We write to you in relation to the planning application submitted by our neighbour at number 51 Woodside Road, Beaumont Park. Having looked at the proposal it seems that it has not taken into consideration the impact it has on neighbouring properties.

49 Woodside Road, Beaumont Park. HD4 5JF

Drawing:
Plans As Proposed

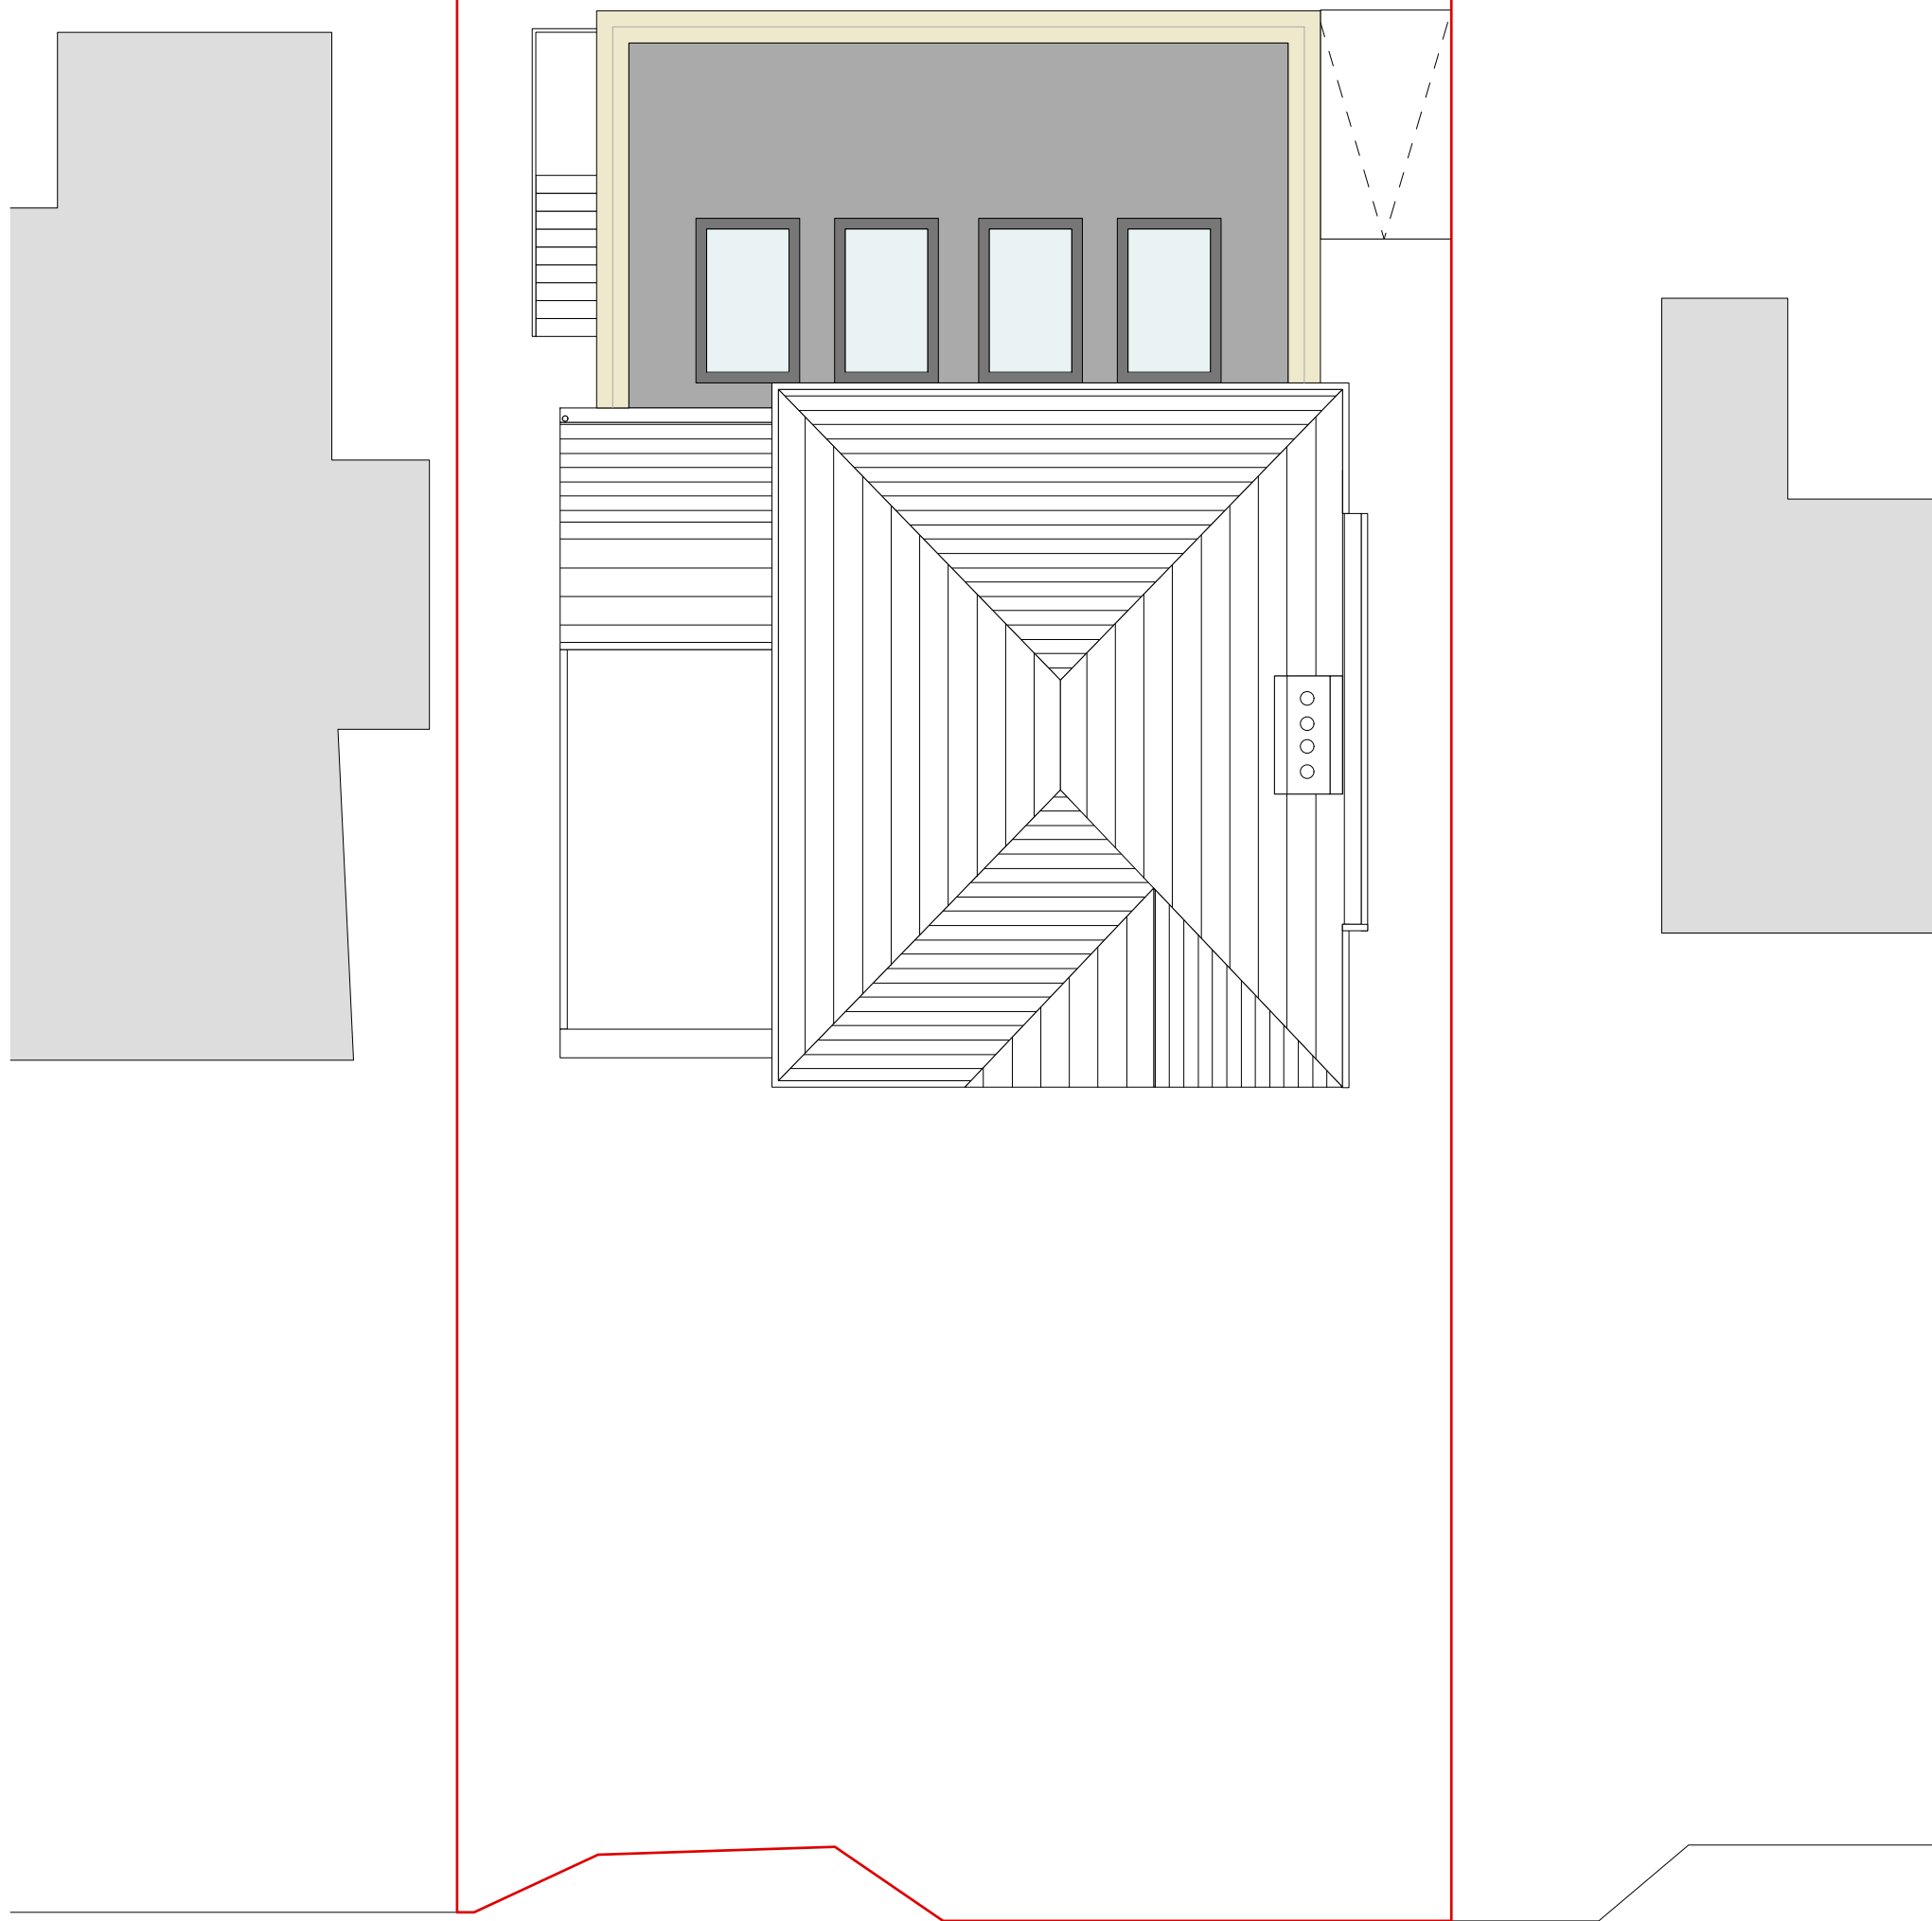
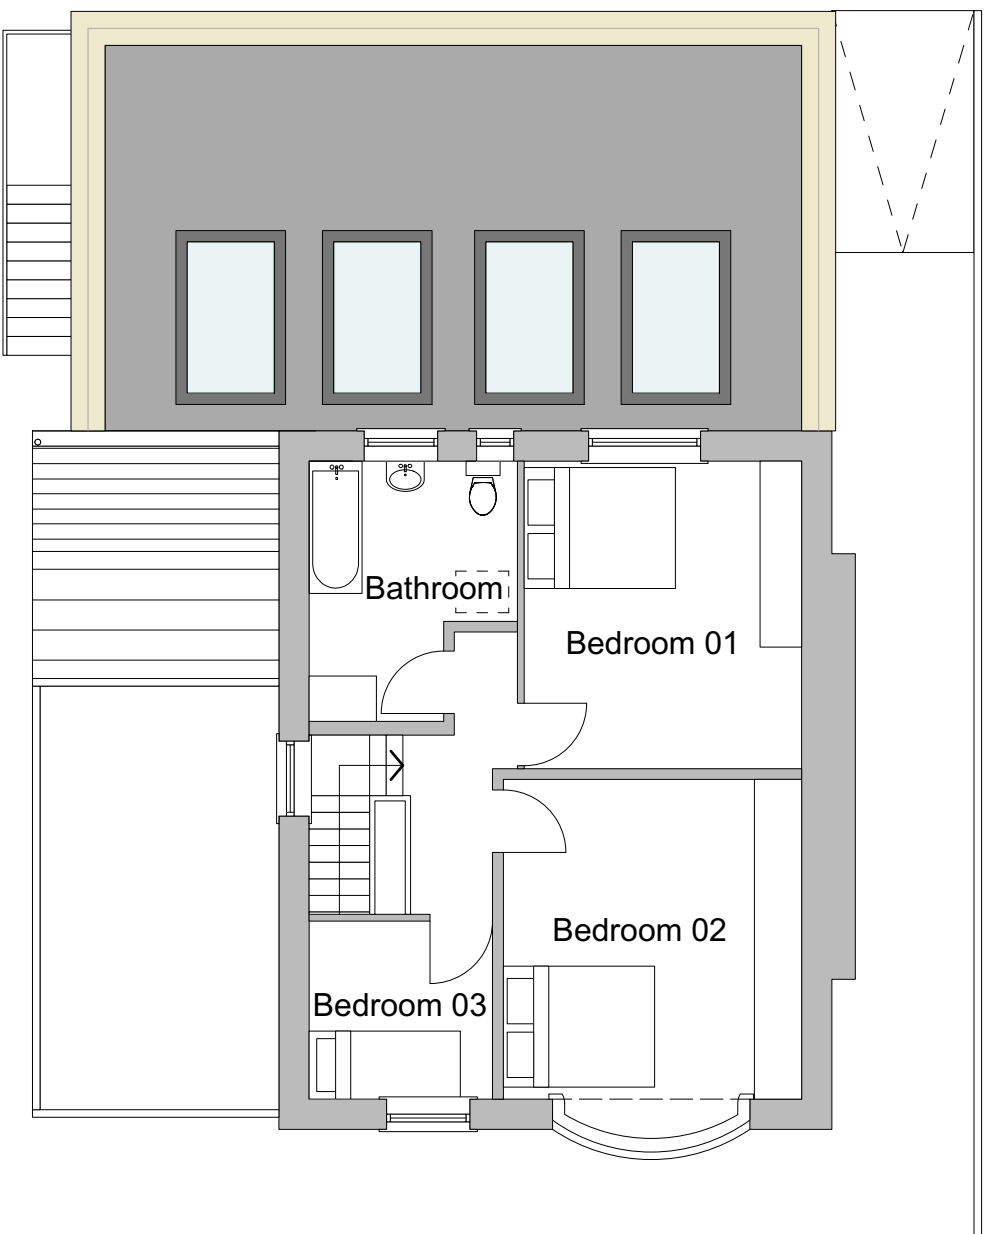
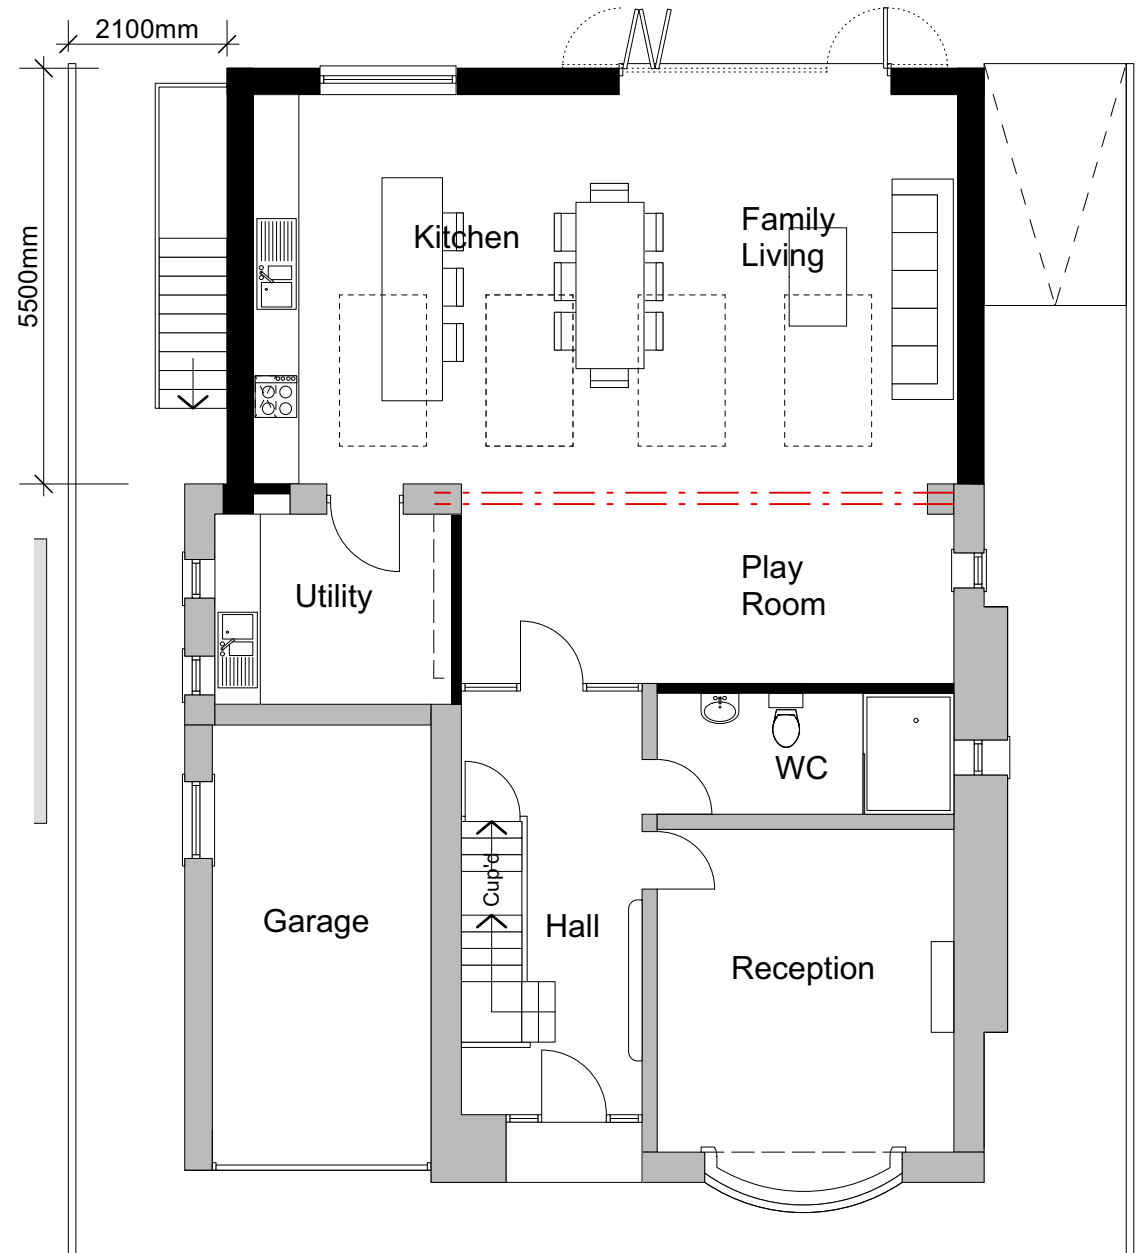
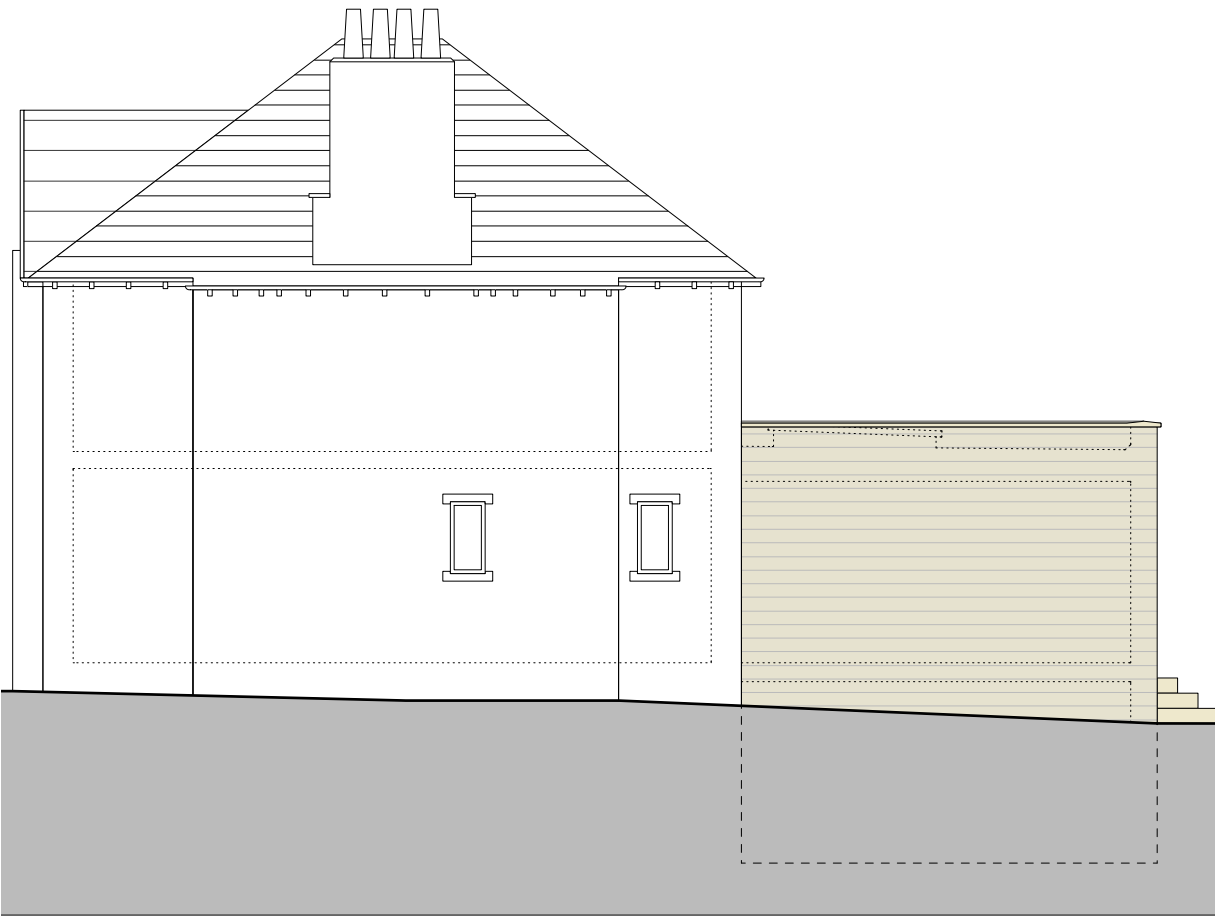
2. SPD sets out at Section 4 '***Key design principle 4: Habitable rooms and side windows Extensions and alterations should consider the design and layout of habitable and non-habitable rooms to reduce conflict between neighbouring properties relating to privacy, light and outlook.***' The proposal is contrary to this and proposes the positioning of windows and a door that directly faces habitable rooms making it an unacceptable proposal that requires clarification on distance, glazing and opening positioning as set out in subsection 4.12. Furthermore, subsection 4.13 stipulates that weight must be given to protecting the right to light for habitable rooms and kitchens. The current proposals length, width and height contravene this as it clearly hinders the passing of light due to its position of **dominance**. Our home is positioned on lower grounding and by the applicants applying the maximum rule it allows the applicant to construct an overbearing and dominating structure that has no consideration for their neighbouring property. We request the Planning Officer to request a reduced height in order for an acceptable amount of light and heat to pass to our property. We note the increased height is to accommodate the build of a basement level workshop however it is unfair and unjust.

3. The SPD sets out, under section 4, **Key design principle 5: Overshadowing/loss of light Extensions and alterations should not adversely affect the amount of natural light presently enjoyed by a neighbouring property.** The proposal is materially affecting the amount of natural light presently enjoyed by our property and the plan, as it currently presents itself it should not be permitted as it will allow the unreasonable overshadowing and dominance over and restrictions of current views enjoyed within habitable rooms and private gardens, especially to the left elevation of our property, the closest to the applicants site proposal.

4. SPD Section 4, sub-section 4.17 sets out an angle rule of 45° which is infringed by the current proposal as an unacceptable amount of light is being lost to the whole of our habitable area in our conservatory when looked at from the side opening windows situated to the left and front. Furthermore, the height of the extension prevents light to project to our habitable area roof windows which have been installed as climate saving measures to provide natural heat and light; this is something we have relied on the most since our occupation of the property and has helped reduce our energy costs. We reiterate, the proposal has failed to consider the elevated positioning it currently sits at, and does not stipulate clearly how tall the proposed height is but from the plan it does position itself as **overbearing and dominating**. It is unjust and unfair to simply allow the maximum rule that is allowed without considering the impact on neighbouring properties.

6. SPD Section 4 sets out ***Key design principle 6: Preventing overbearing impact Extensions and alterations should not unduly reduce the outlook from a neighbouring property.*** The height and closeness of the stone proposal is extensive, although it is set at a 1 meter distance from our boundary the application of the rule should not be considered as acceptable as each property should be assessed on its individual merits. In this proposal the closeness and height of the proposed extension will clearly add on the dominating, overbearing and intrusive nature of the proposal. It is noted the extension sets itself back from its original side building line however it is also noted that the wrap around balcony/platform would edge all the way to the end of the property line hence the extension being something that has in fact been built to the end of the property line and not wholly in line with the SPD requirements. By allowing the extended height and massing closer to our property is detrimental because it allows it to be an oppressive feature which would tower over our habitable area. It would reduce the natural light to the side elevation windows and roof areas of our property where openings are located. Given the projection of the proposal located close to our boundary it is of our opinion that the works would result in an oppressive development that would be overbearing and dominant when viewed from neighbouring properties including the amenity spaces. It would be appreciated if the applicant could set the extension further away from the shared boundary line and not simply apply the rule and reflect in its plan the advantaged elevation the property sits at.

sits at and our property being situated lower. By allowing the extended height and projection would be detrimental. To have the overall scale in terms of height and massing closer to our property is detrimental because it allows it to be an oppressive feature which would tower over our 3 meter by 3 meter single storey rear extension. It would reduce the natural light to the side elevation windows and roof areas of our property where openings are located. Given the projection of the proposal located close to our boundary it is of our opinion that the works would result in an oppressive development that would be overbearing and dominant when viewed from neighbouring properties including the amenity spaces.

To conclude, it would be highly appreciated and be more considerate of the applicants to scale back on their proposed plans and have plans that reflect that they have thought about and had a sympathetic interest towards their neighbouring property. A plan that remains within the 4 meter projection rule would be more considerate; a plan that scales down the height of the development would be less dominating and overbearing; a plan that shifts the massing further away from the house boundary line would allow the reduction of an overbearing and dominating effect as well as a reduction in the invasion of privacy with the proposed door and windows that currently face our habitable areas.
